From: Chance, Jennifer
Sent: 22 January 2026 14:58
To: _planningadvice
Subject: H01-1245-25

For the sake of clarity, I have no objections to the housing development of 3 properties (plots 1-3). The objections are based solely on the proposed conversion of the Engine Shed (marked on plan as plots 4-5).

The Engine Shed (A.K.A the Goods Shed) is considered to be a non-designated heritage asset (NDHA) by virtue of it's attractive historic detailing and importance to the agricultural history of the locale, being recorded in the Lincolnshire HER under reference: MLI126584, which describes the building like so:

PROPOSED ELEVATIONS

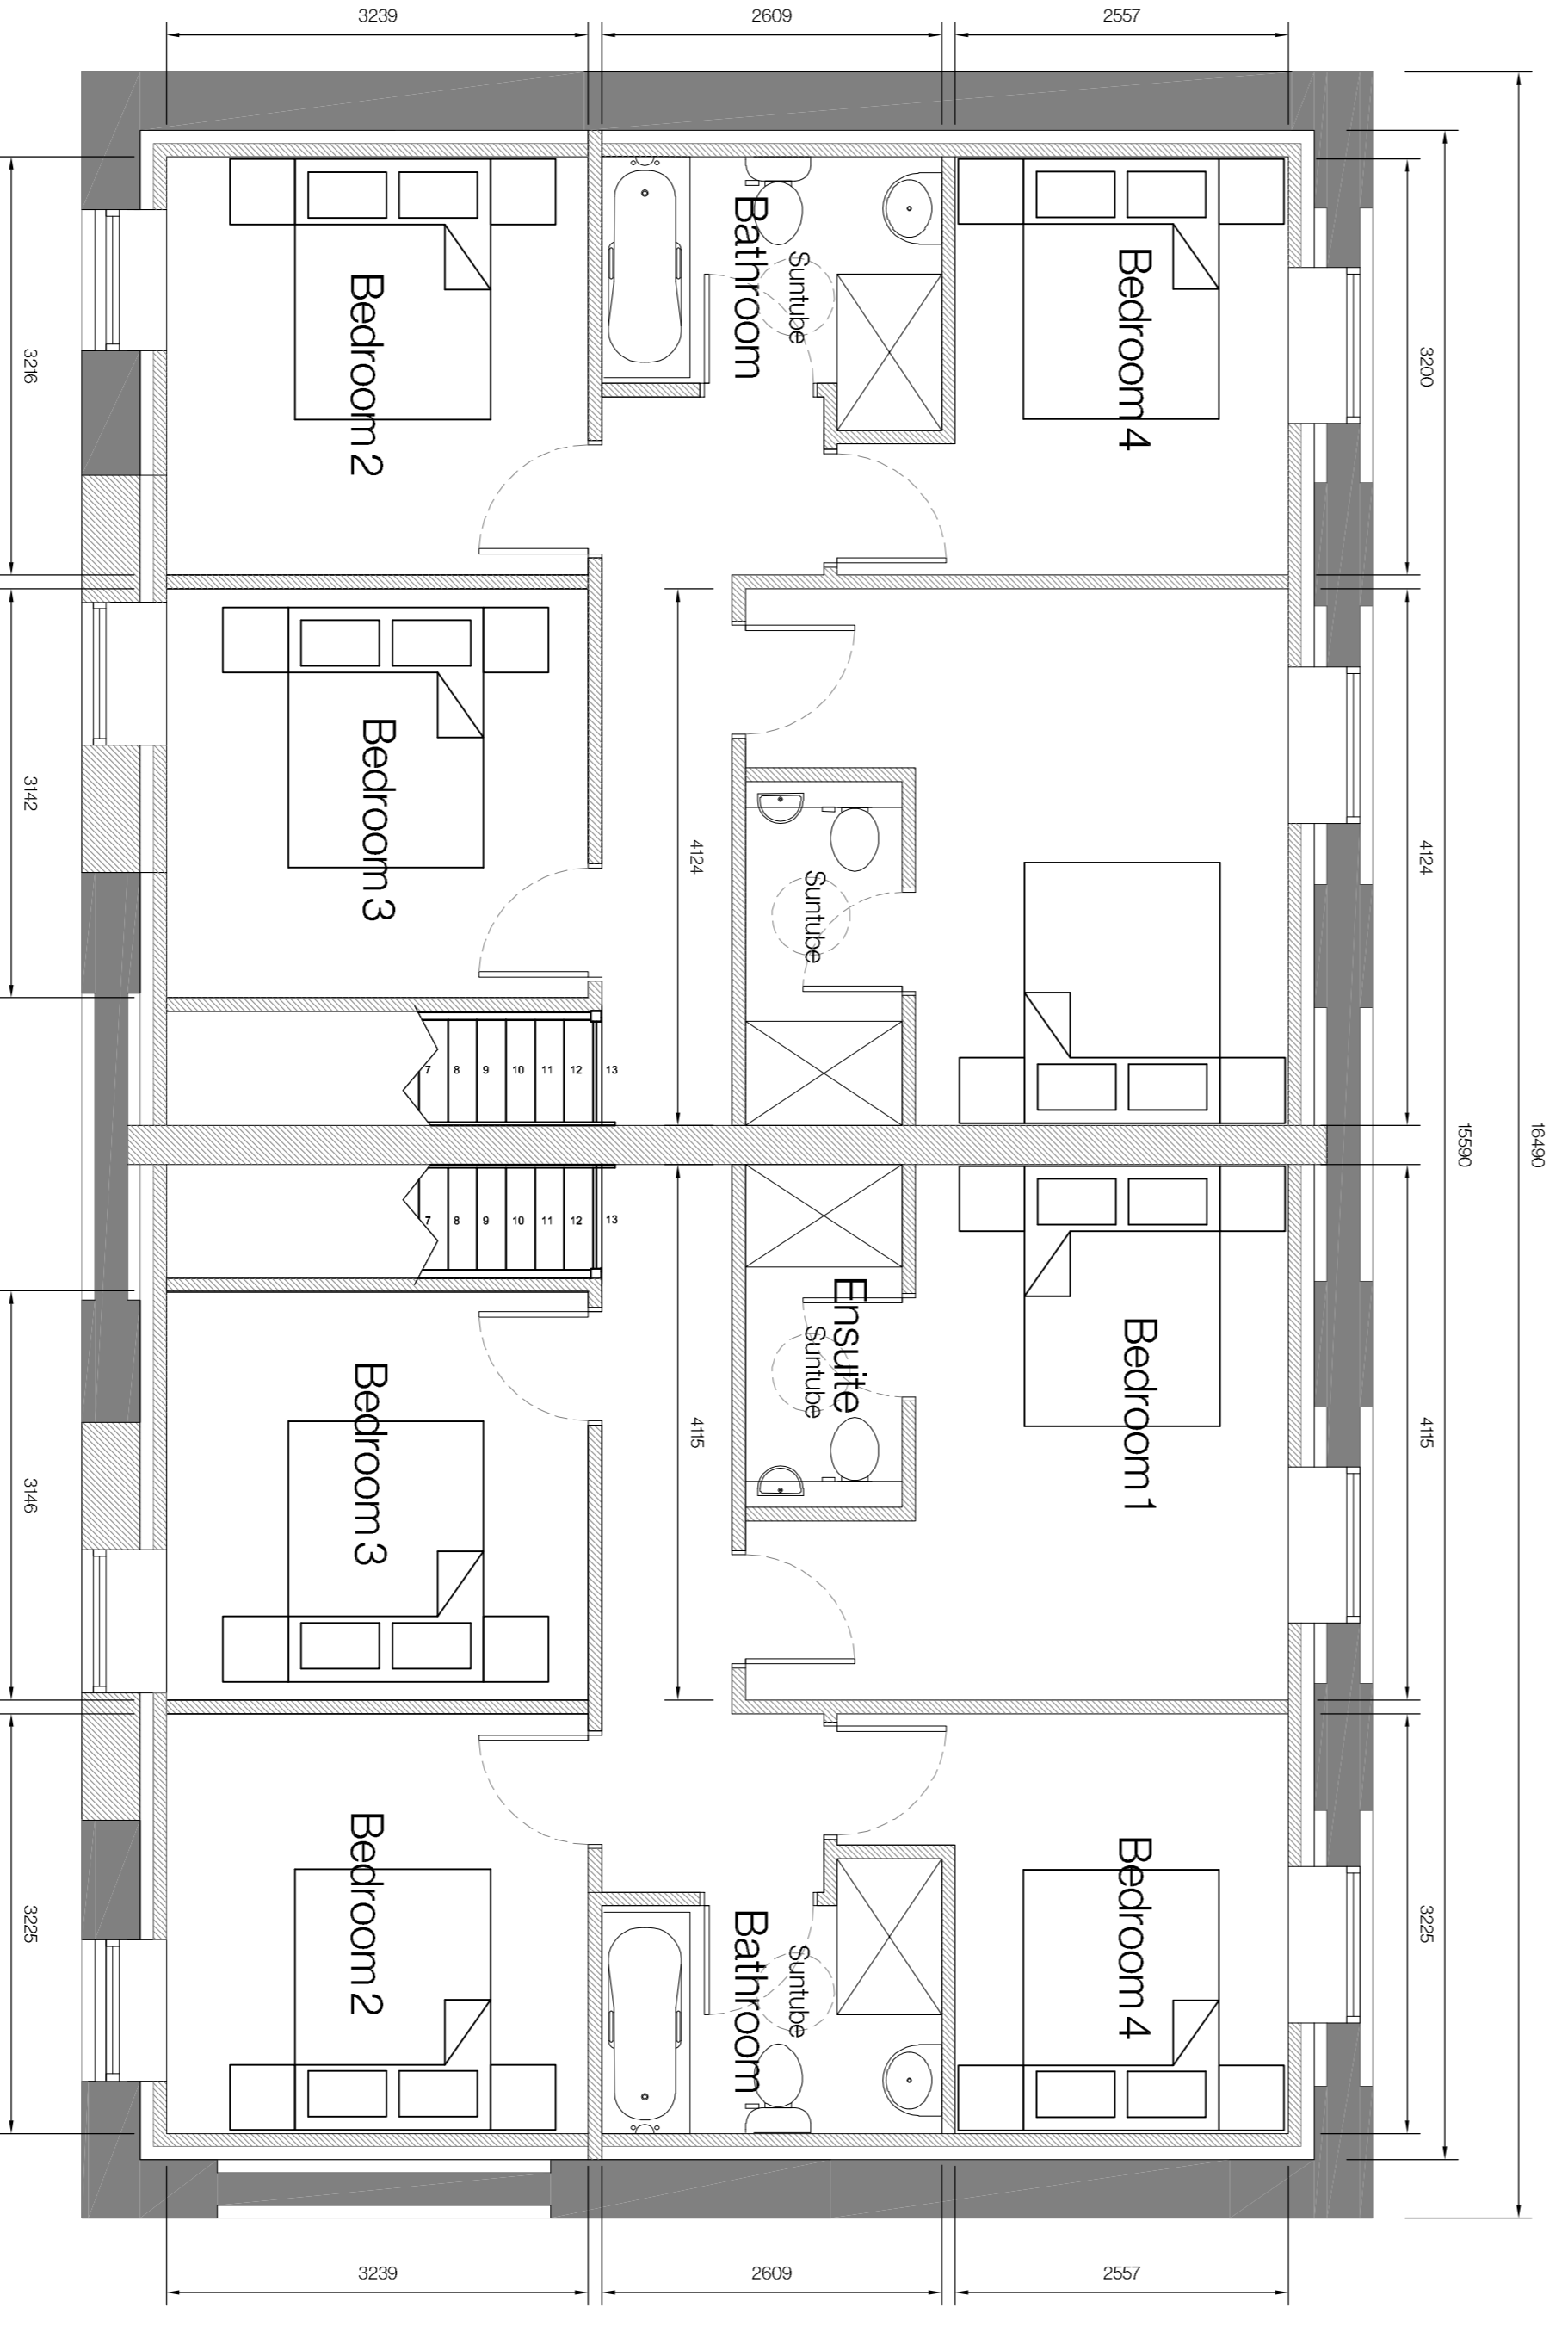
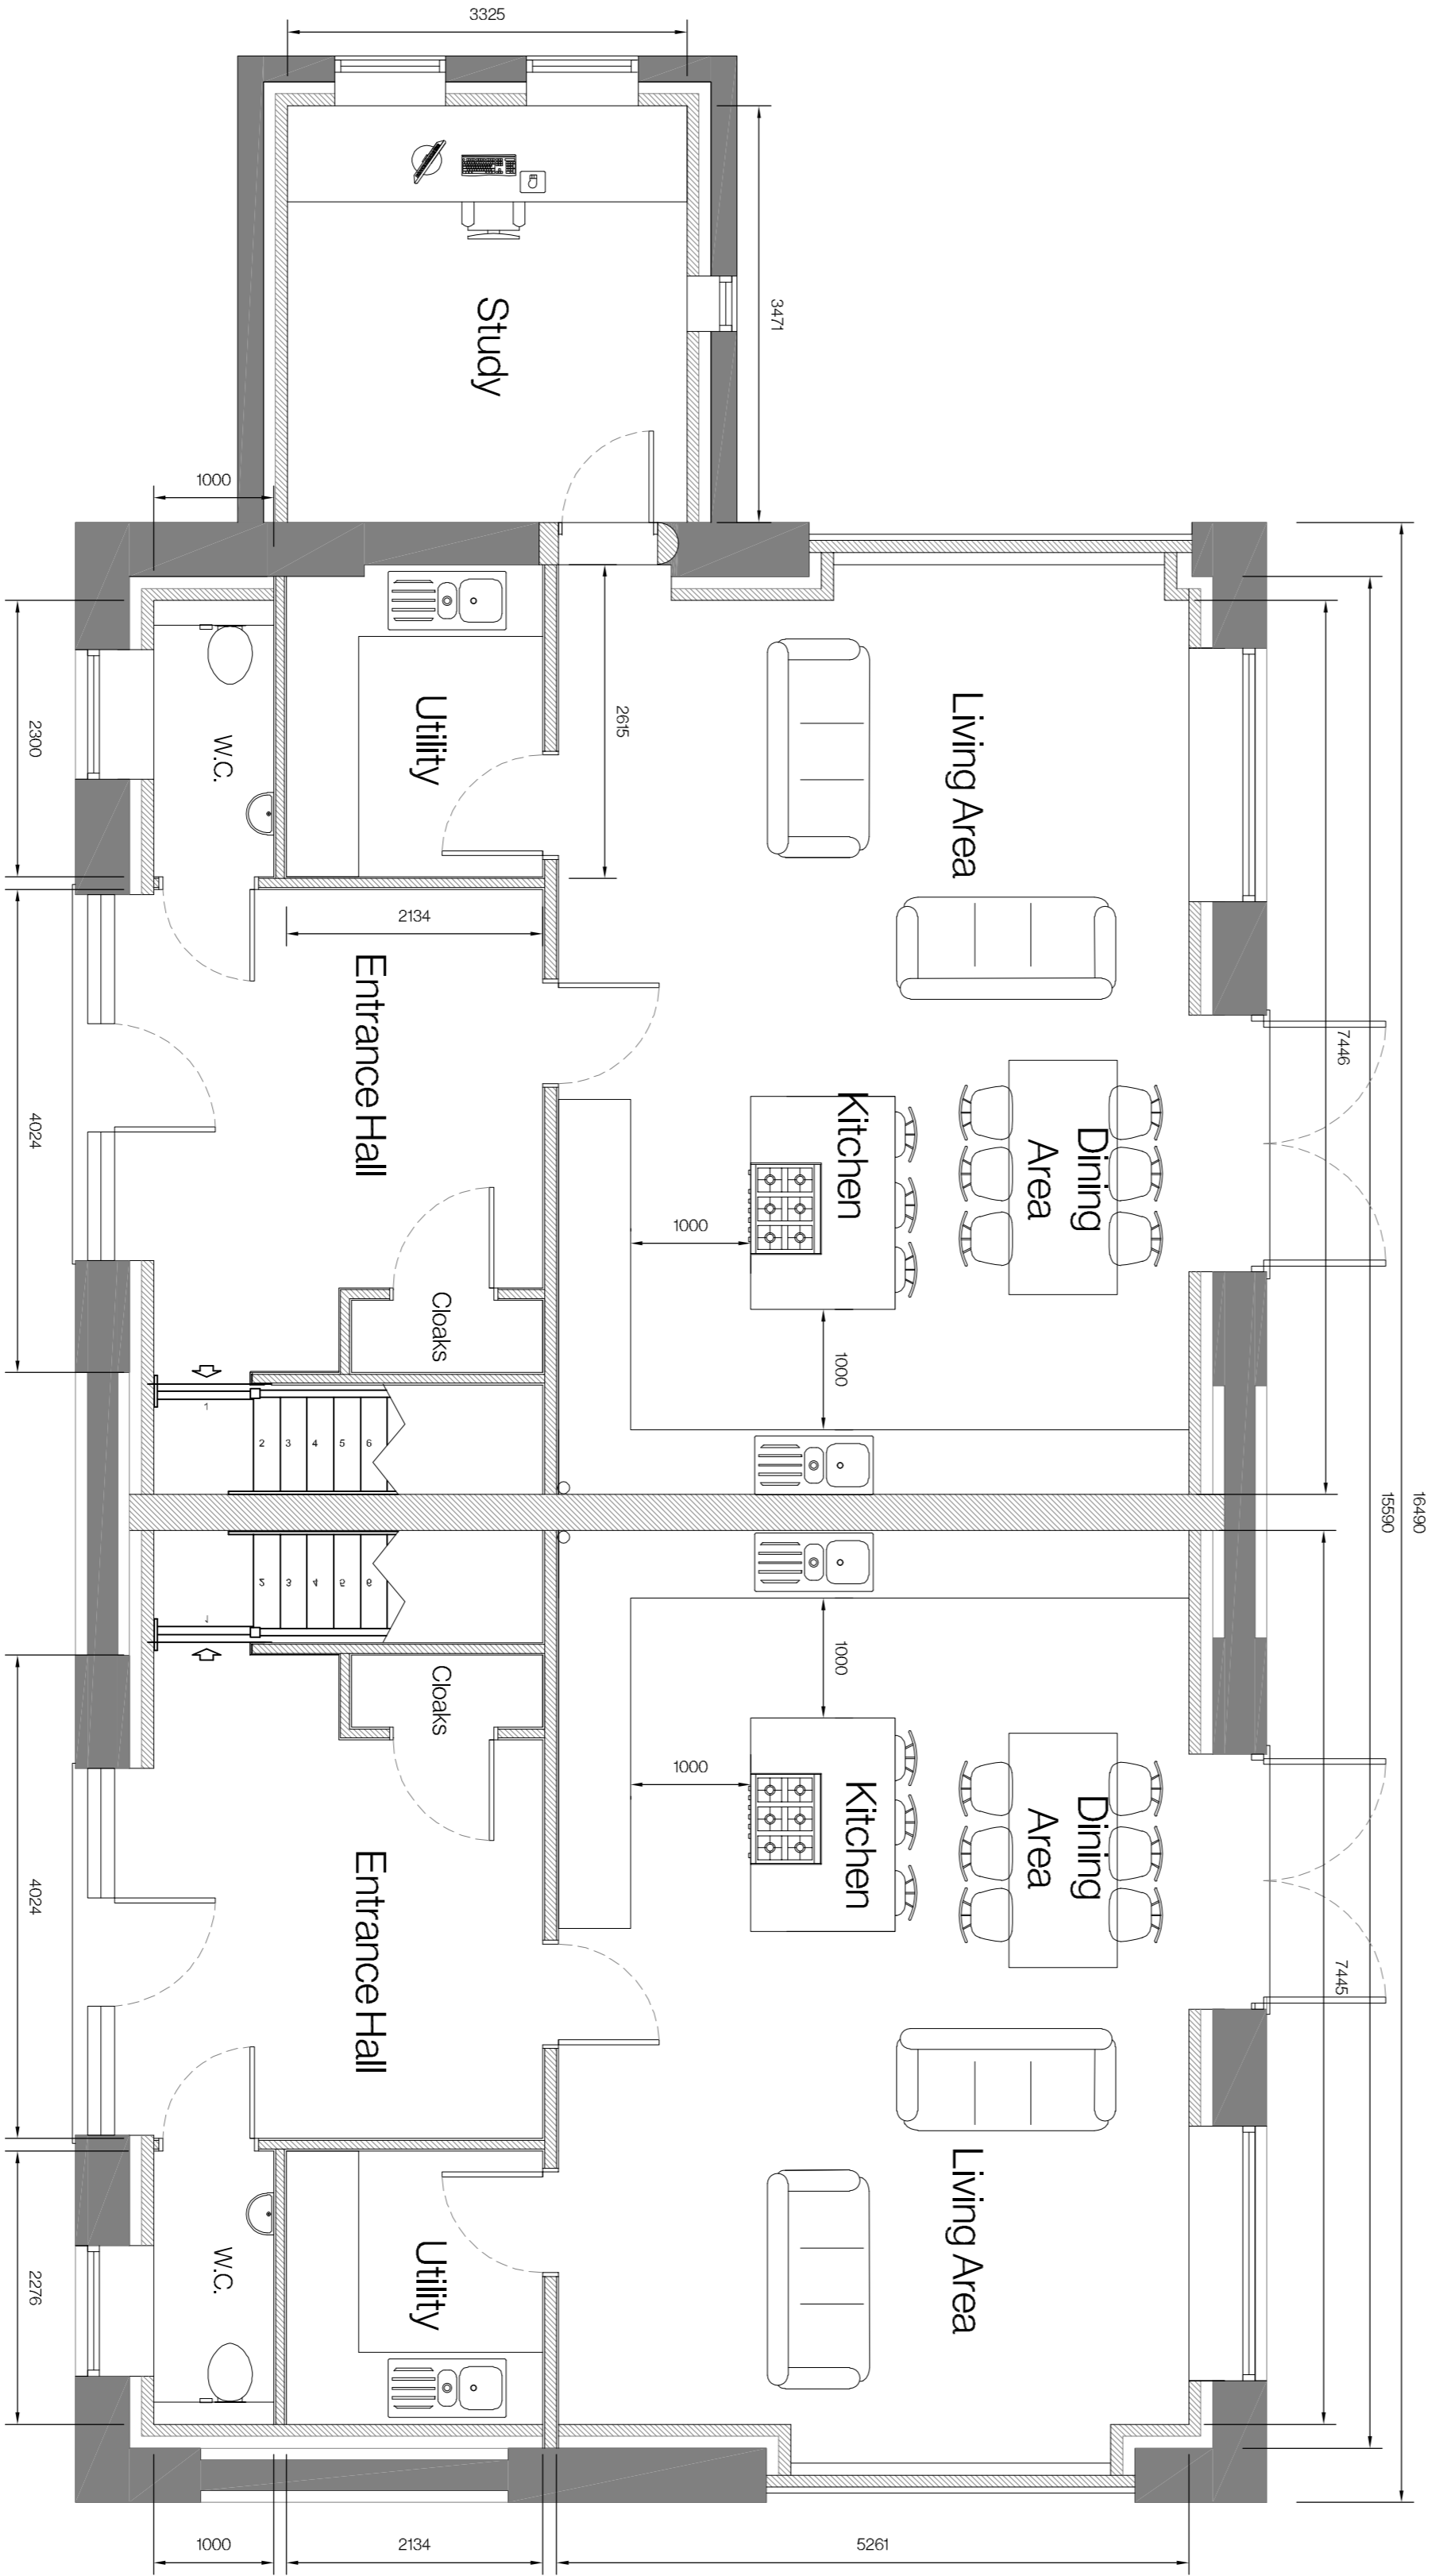
The proposed conversion of the Goods Shed seemingly makes no attempt at design sympathy with this attractive former rail building; seeking to infill and remove all readability of historic openings, reveals and recesses with marley boarding, and replacing character windows and doors with standard dimension PVC fenestration with absolutely no relation to the character of the existing. So great is the proposed harm to the NDHA, that I would suggest that the scale of harm should be recognised as at the higher end of ‘substantial’ as it seeks to effectively remove or substantially alter more or less every character feature of the structure, save for the chimney stack and pot, and would modernise the appearance of the asset to an extreme degree, resulting in an unattractive form of development. In accordance with this view, I would therefore recommend that without amendment, Para. 216 of the NPPF should be used as justification for a refusal.

Should the applicant be minded to seek amendment, I would suggest that the whole principle behind the proposal should be rethought totally. The agreed class Q conversion under application reference: H01-0098-24 showed that a sensitive and high quality conversion of this building is not outside of the bounds of design, and should be seen as a useful baseline standard in informing what form any future plans for the Goods Shed may take.
